# Grading & Erosion Control Plan\_V2 Redline.pdf Markup Summary

DEN/M/153722.CB.CB/PgVT-1/8-99

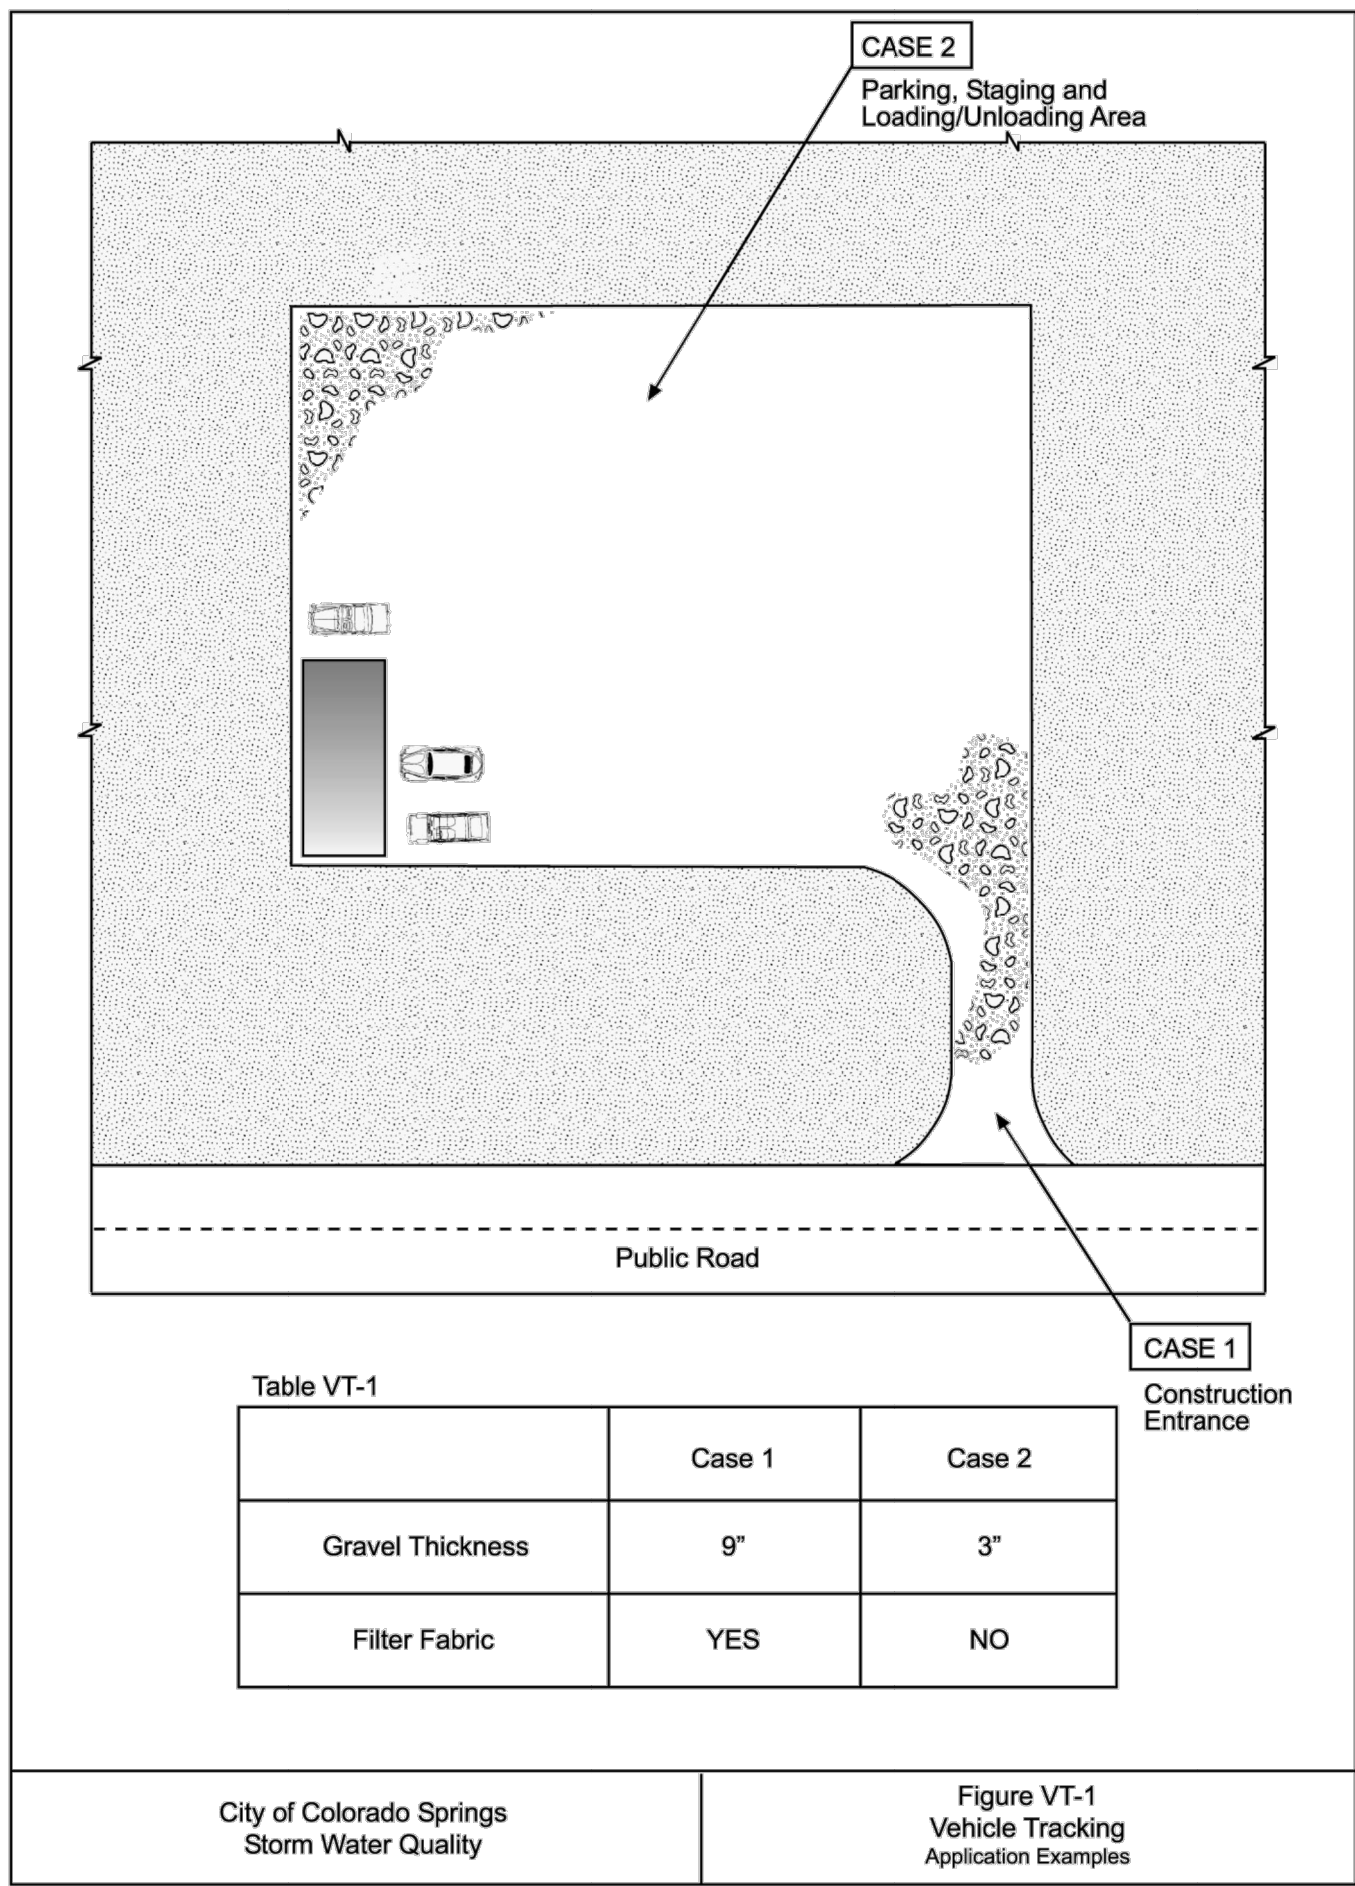
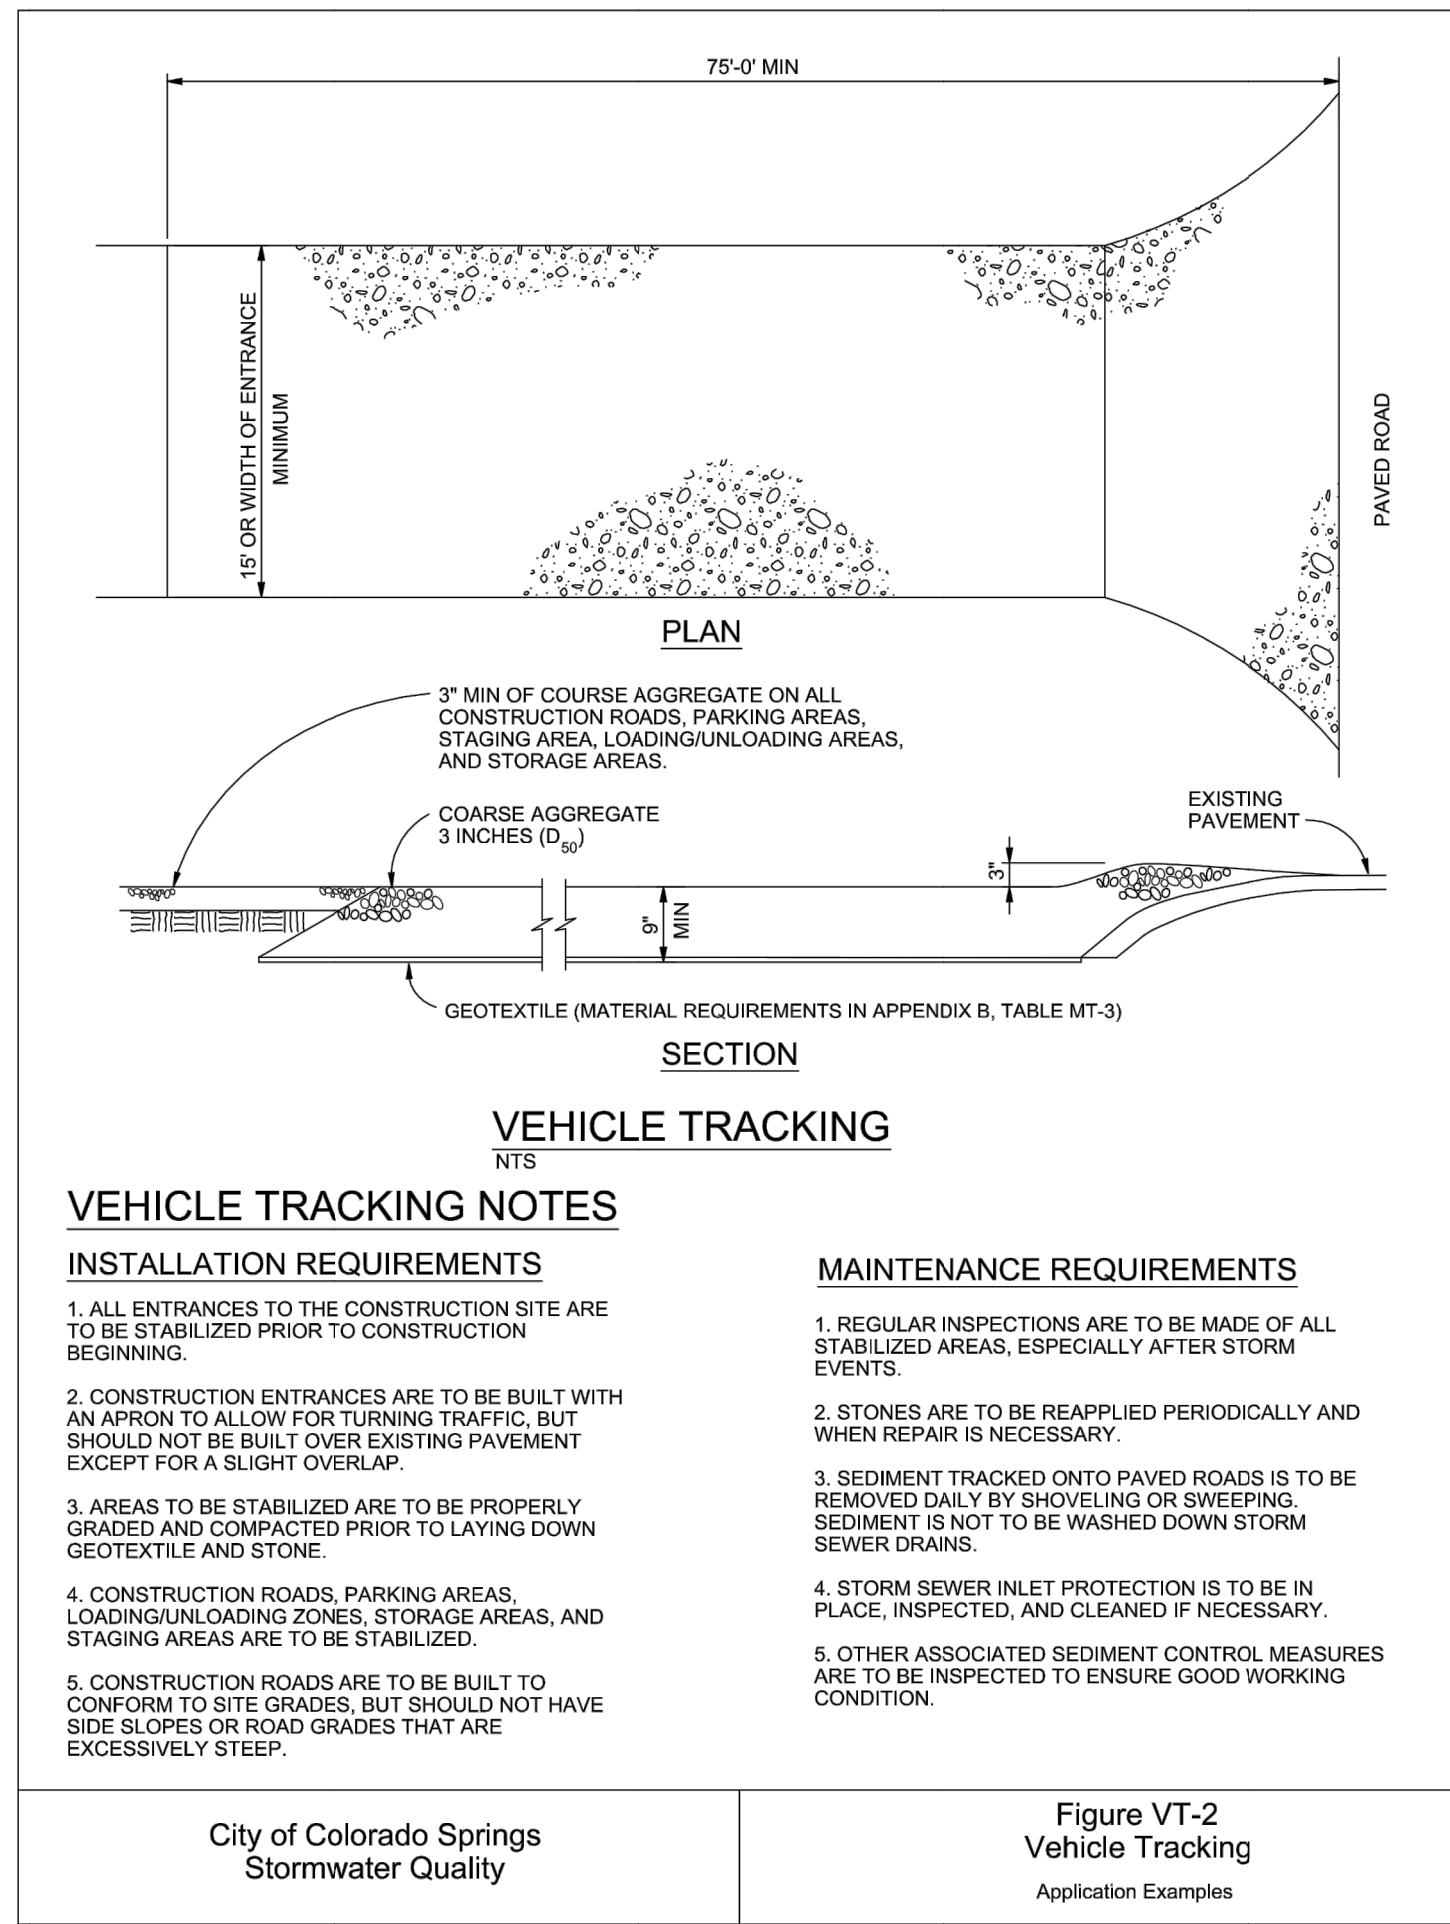
replace with EPC approved VTC detail (VT-1 and  
VT-2 in DCMv2, Chap 3.3) or revise to be 75ft min  
length.  
unresolved.

replace with EPC approved VTC detail (VT-1 and VT-2 in DCMv2, Chap 3.3) or revise to be 75ft min length.
